LAND USE AND ACCESS

LSC Responses to TIS Redline Comments

Figure 3b

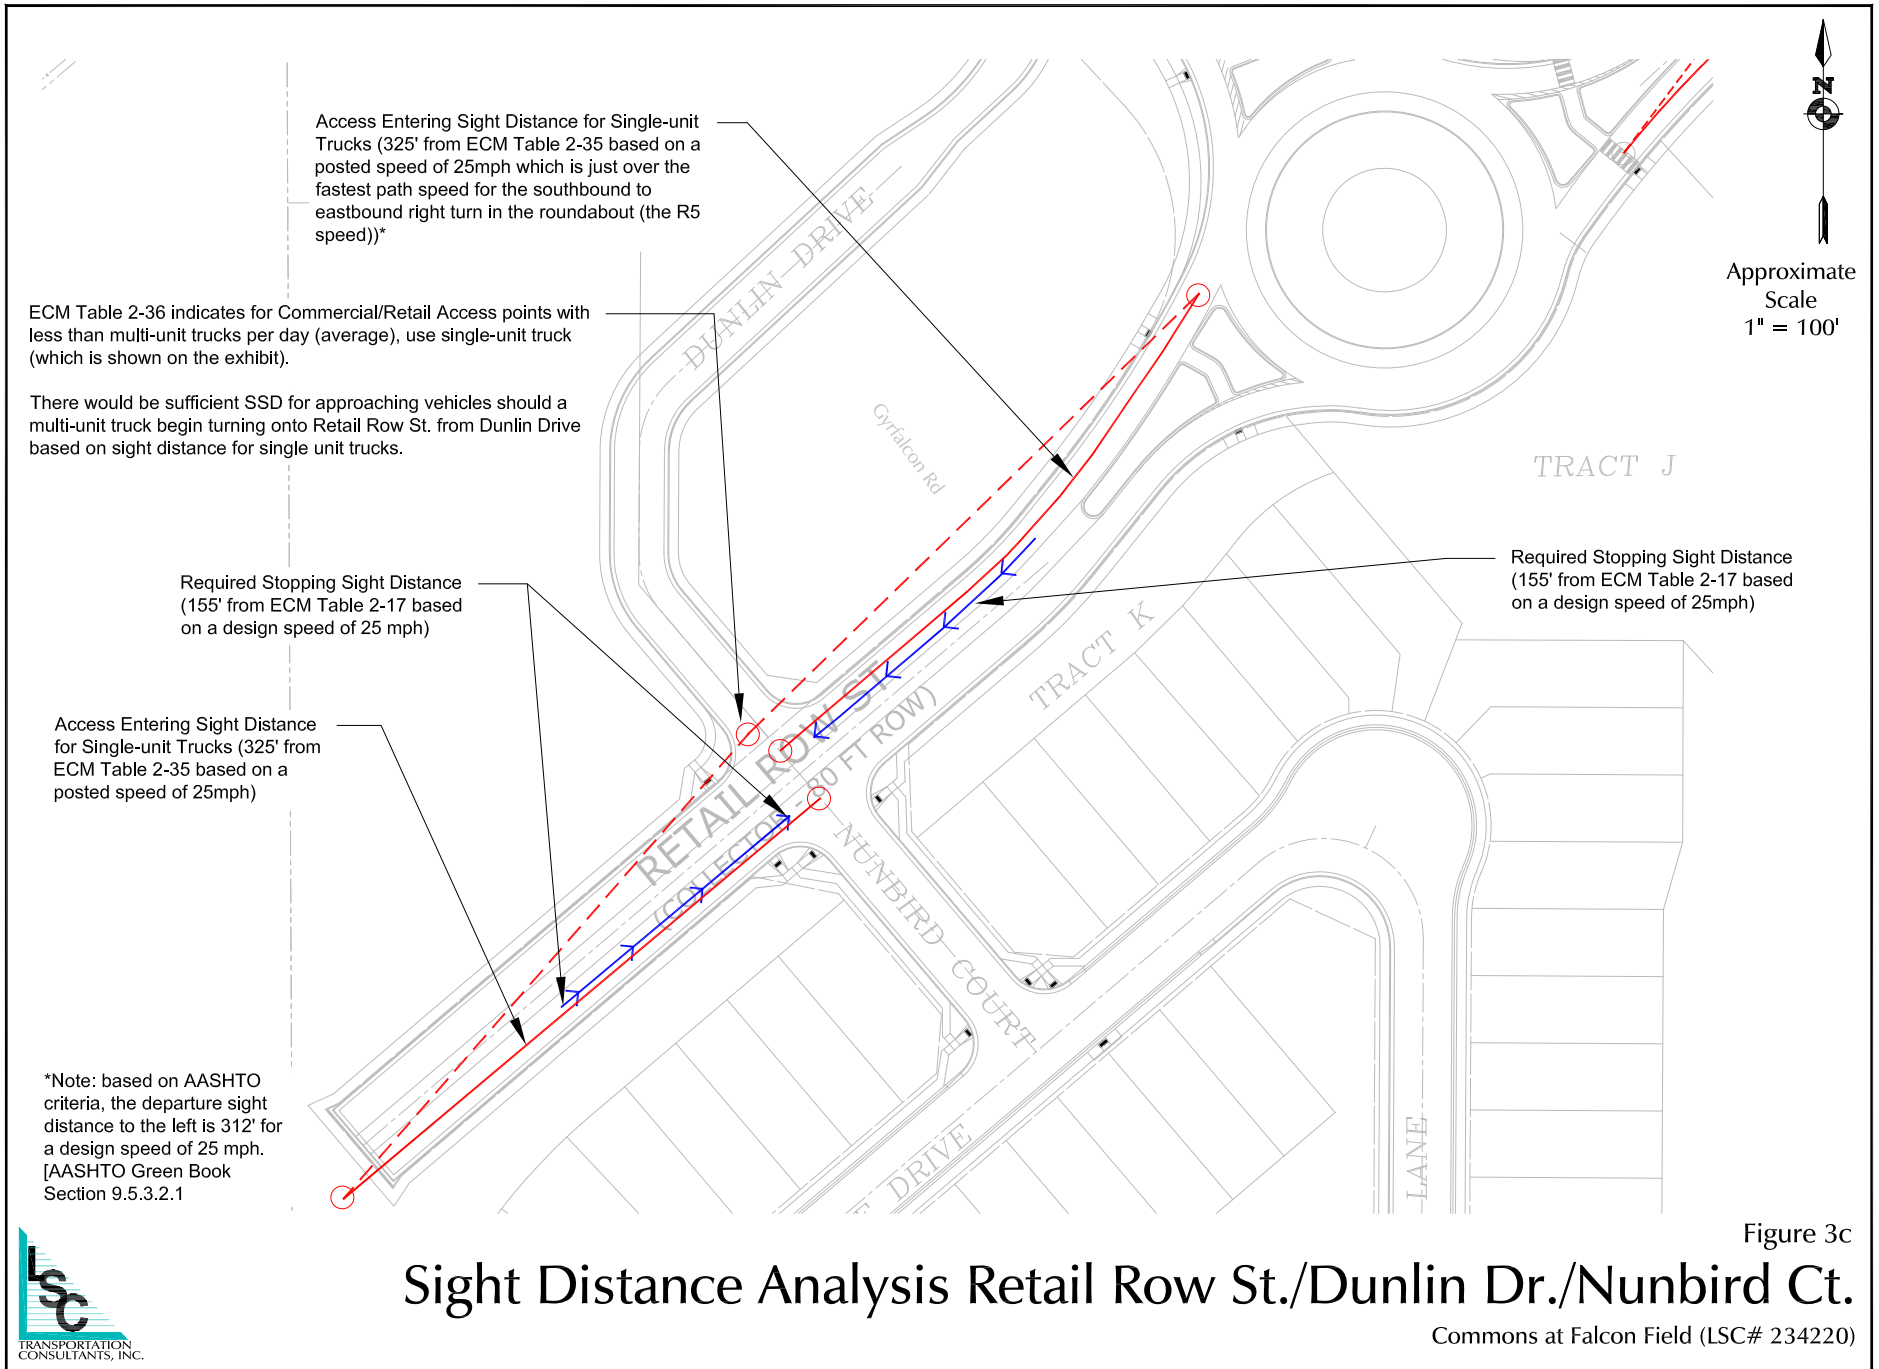
Comments on the preliminary plan have been provided regarding the private roads and the proposed cross section. Due to the volume of traffic and lots being accessed from these private road the Sight distance criteria for roadways as opposed to driveways should be used on the easterly access. Please revise the sight distance analysis accordingly. Additionally, recommendations as to the classification & cross section of the private roadway shall be provided.

Comments on the preliminary plan have been provided regarding the private roads and the proposed cross section. Due to the volume of traffic and lots being accessed from these private road the Sight distance criteria for roadways as opposed to driveways should be used on the easterly access. Please revise the sight distance analysis accordingly. Additionally, recommendations as to the classification & cross section of the private roadway shall be provided.

LSC Response: The sight-distance analysis has been updated based on the revised site plan and a modified Urban Non-Residential Collector cross section for Retail Row Street.

The analysis has been revised at the east access based on sight-distance criteria for roadway intersections. The report also references the deviation requests, which also address sight distance.

The exhibits were included in the recently-submitted deviation requests, but copies of those exhibits have been included in this TIS report as "figures."

Figure 3d

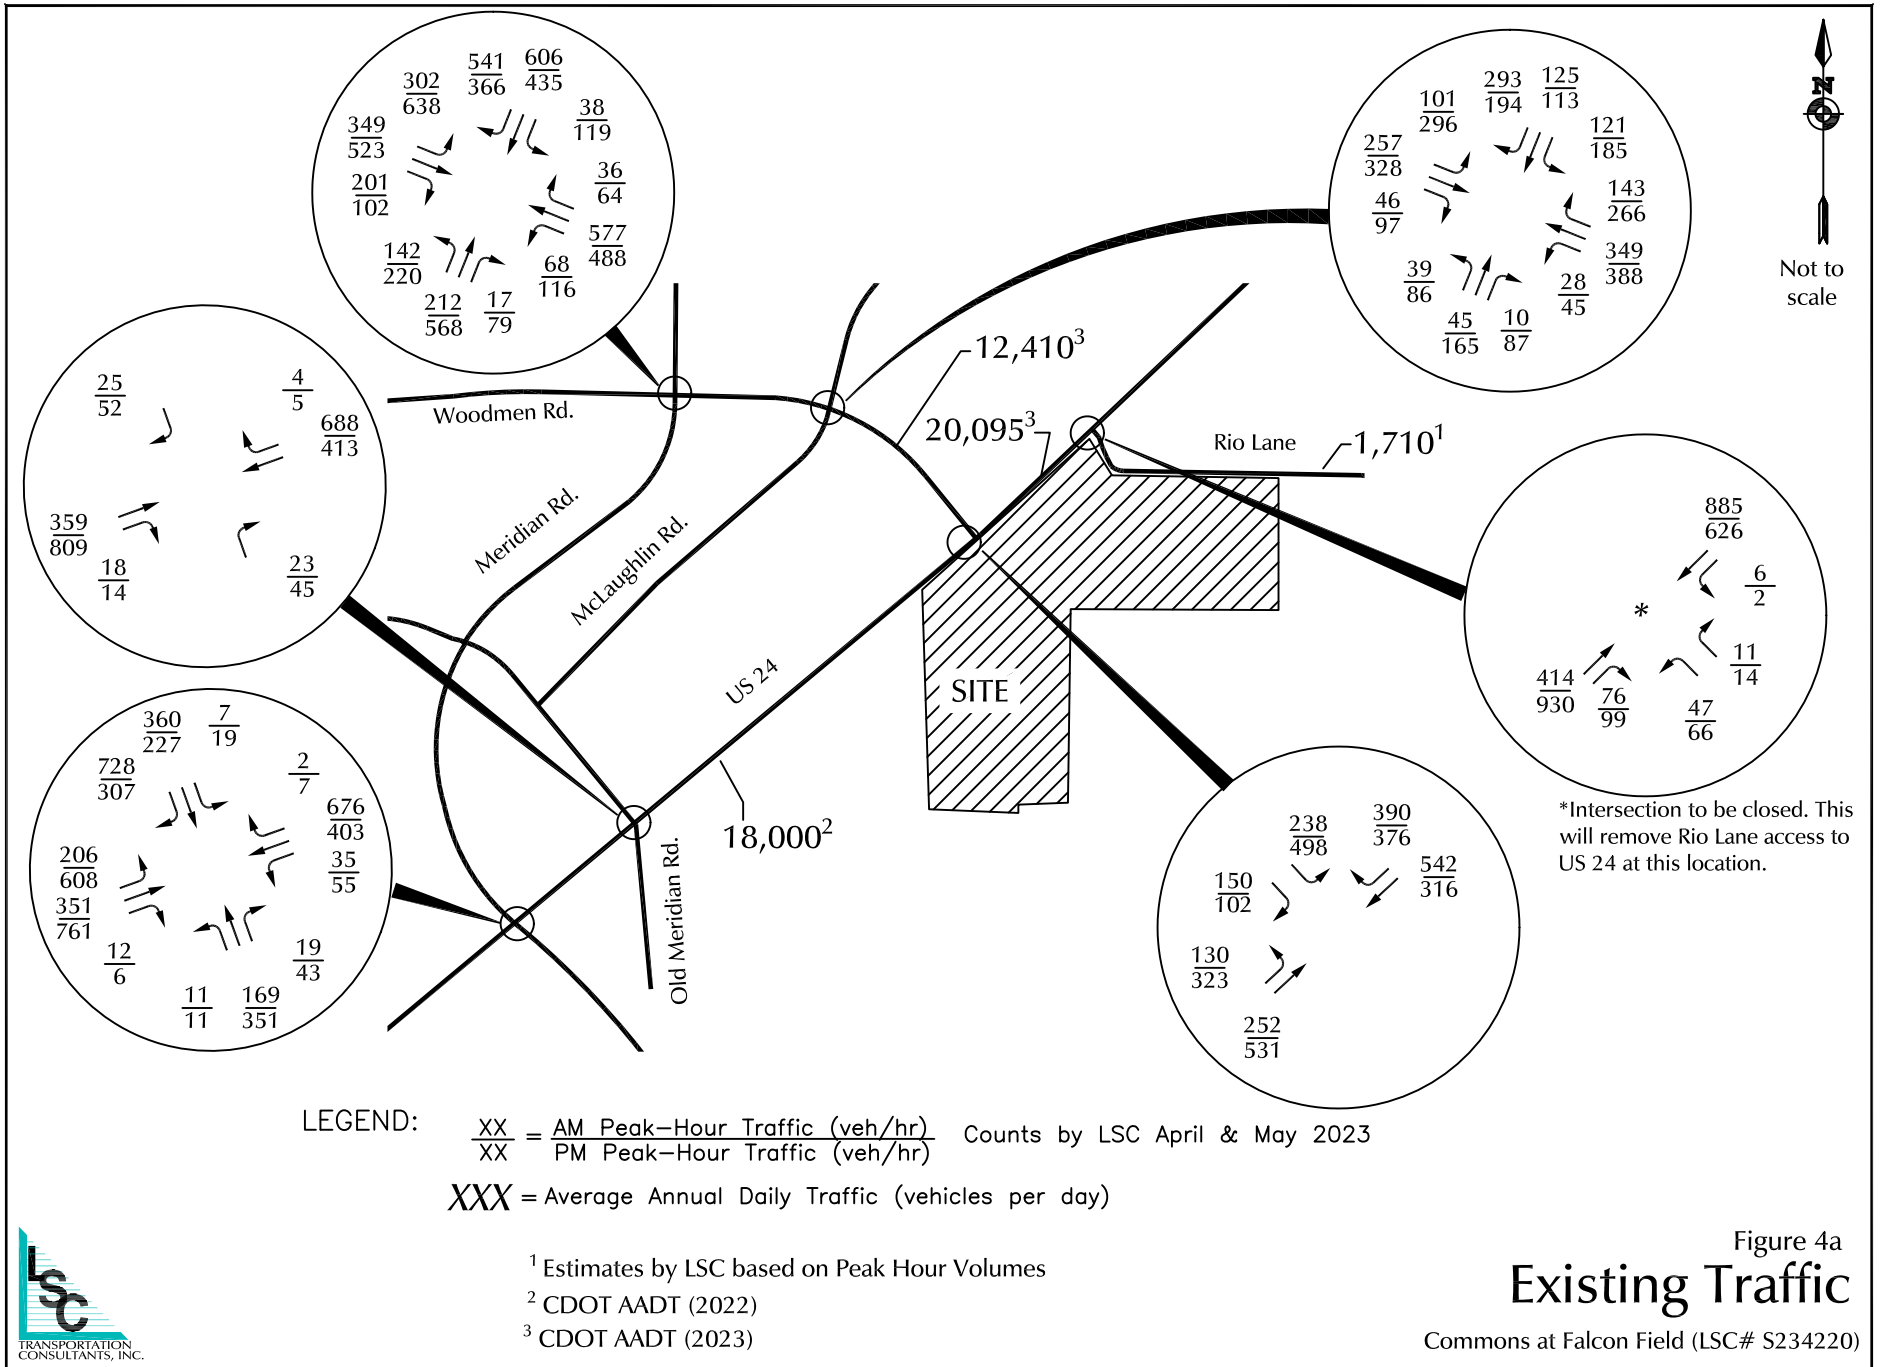
A sight distance easement will be required to keep obstructions outside the line of sight.

LSC Response: Comment noted. The sight-distance analysis has been updated - see response to the comment above for details.

Figure 8
2044 Background Conditions
 Commons at Falcon Field (LSC# S234220)

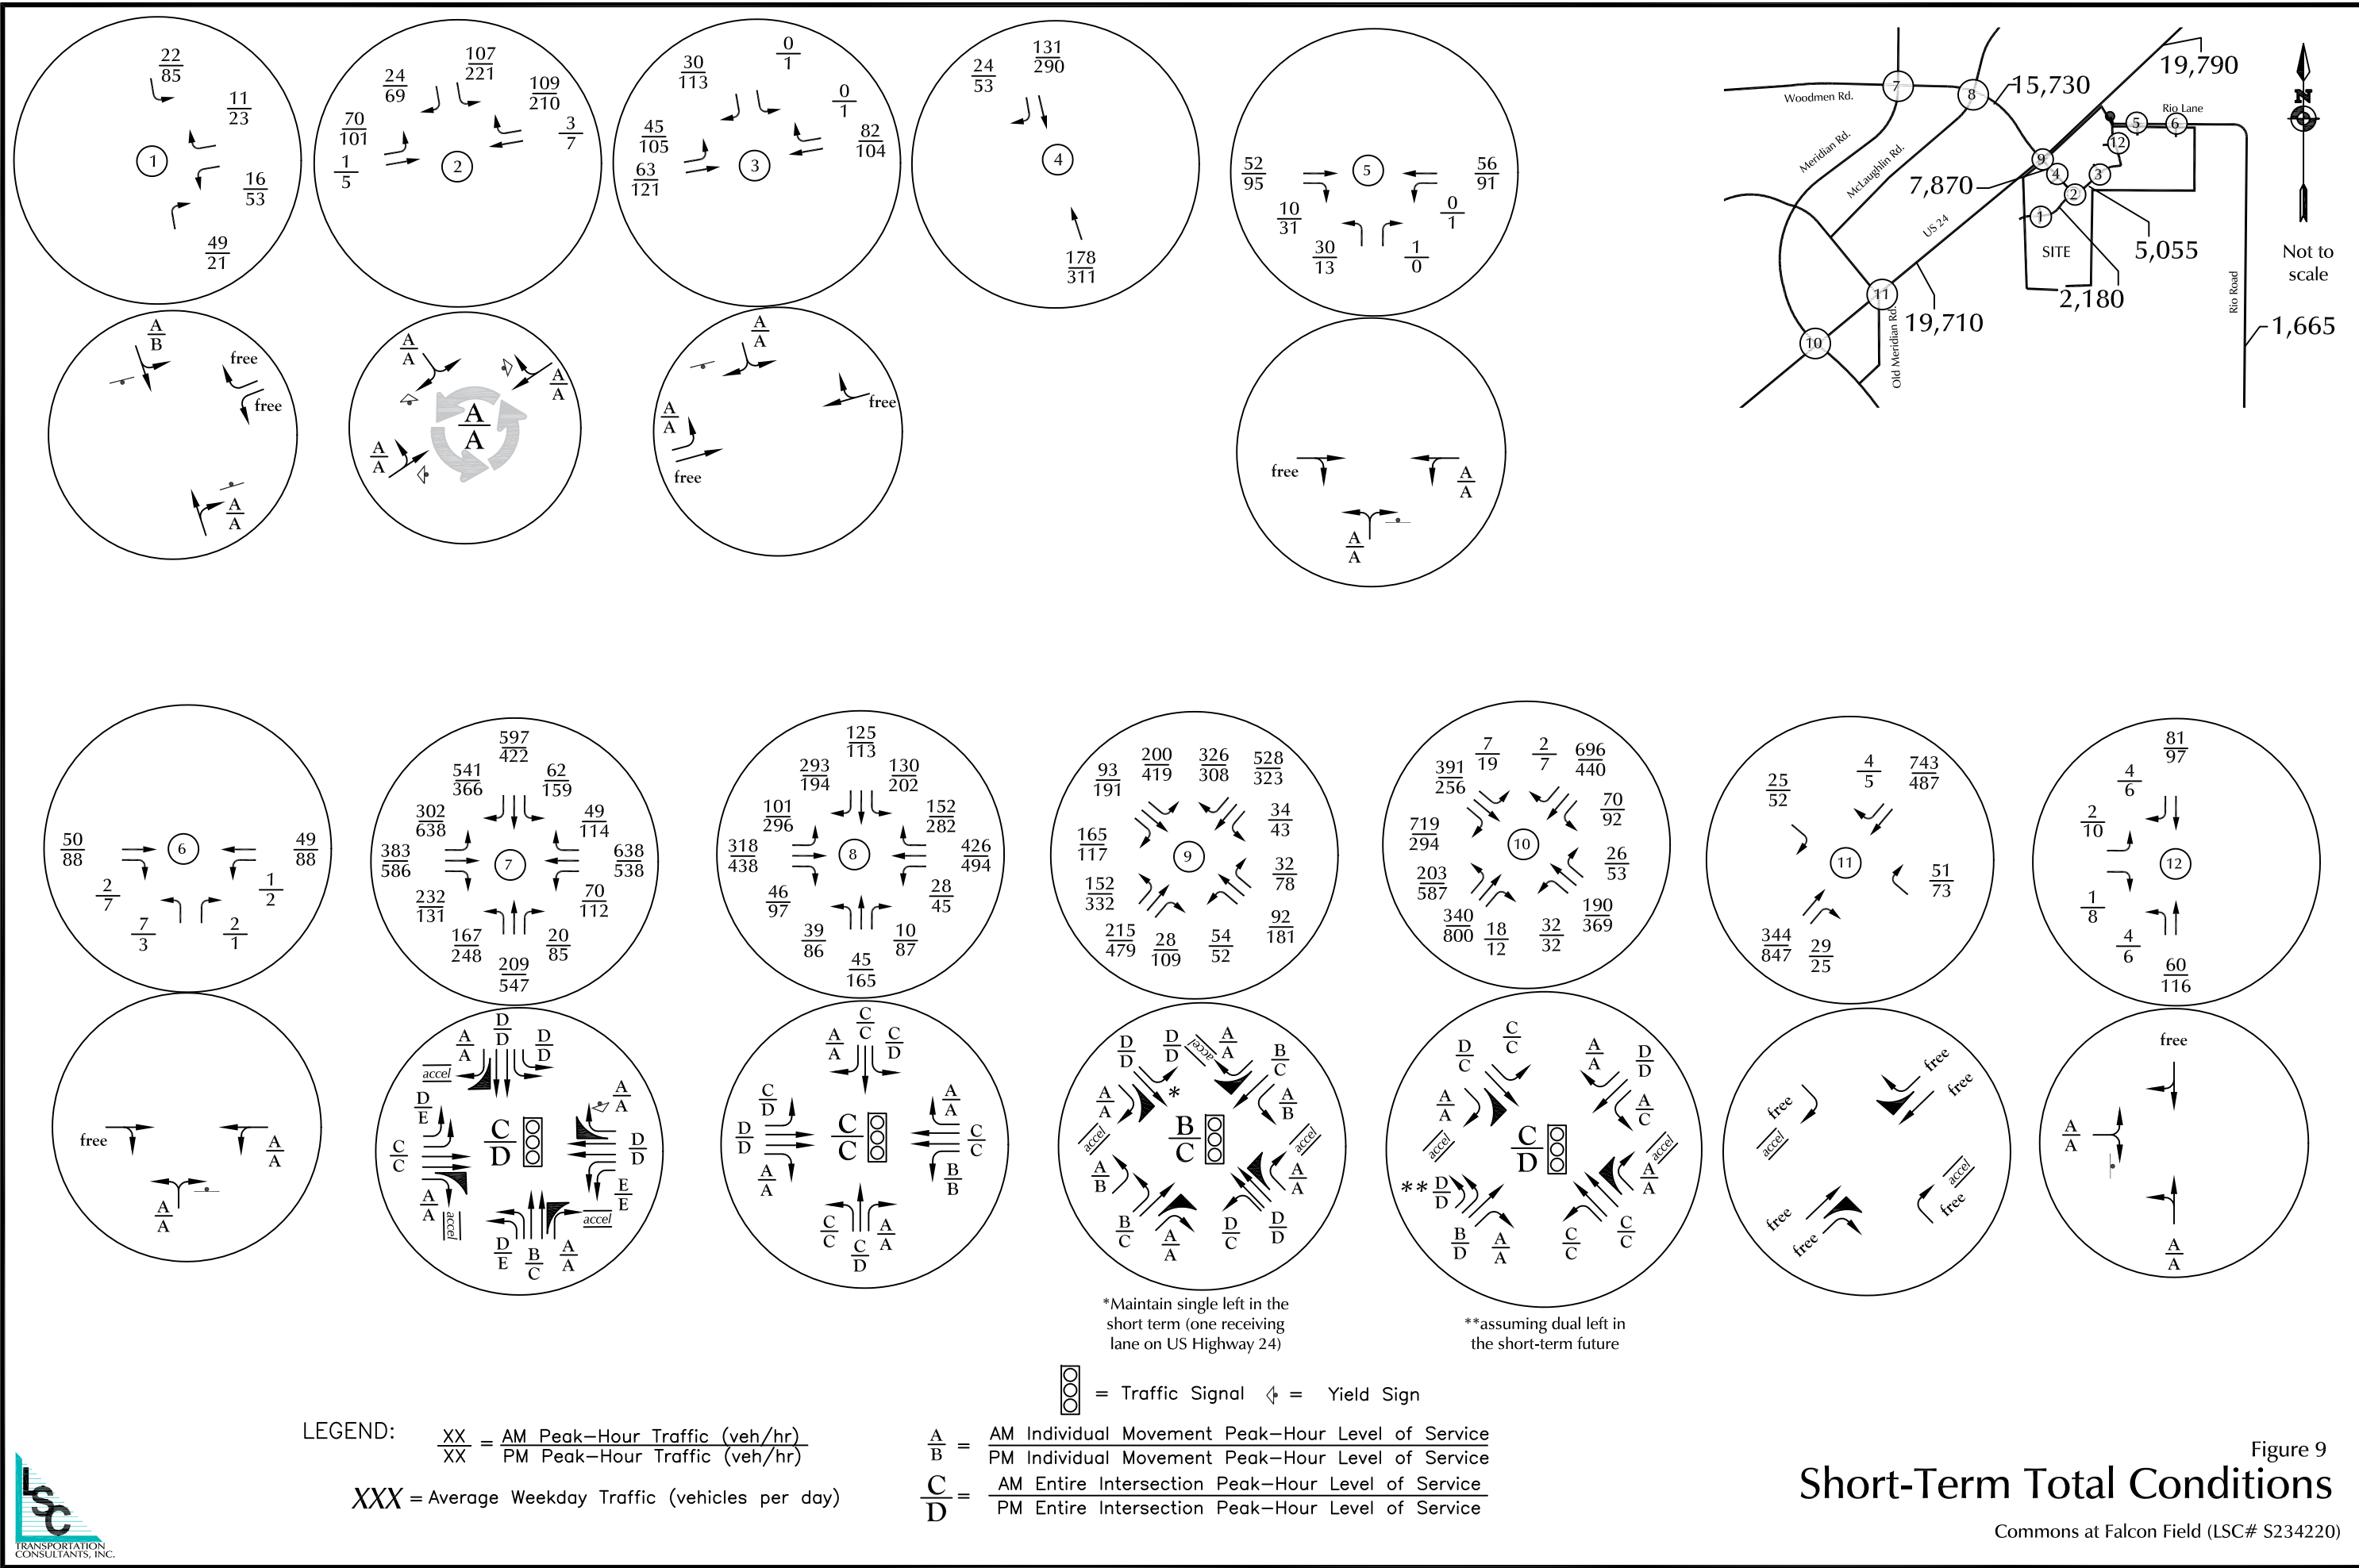
[fix call out](#)

Author: kdferrin Subject: Sticky Note Date: 3/6/2024 4:36:52 PM
LSC Response: Revised as requested.
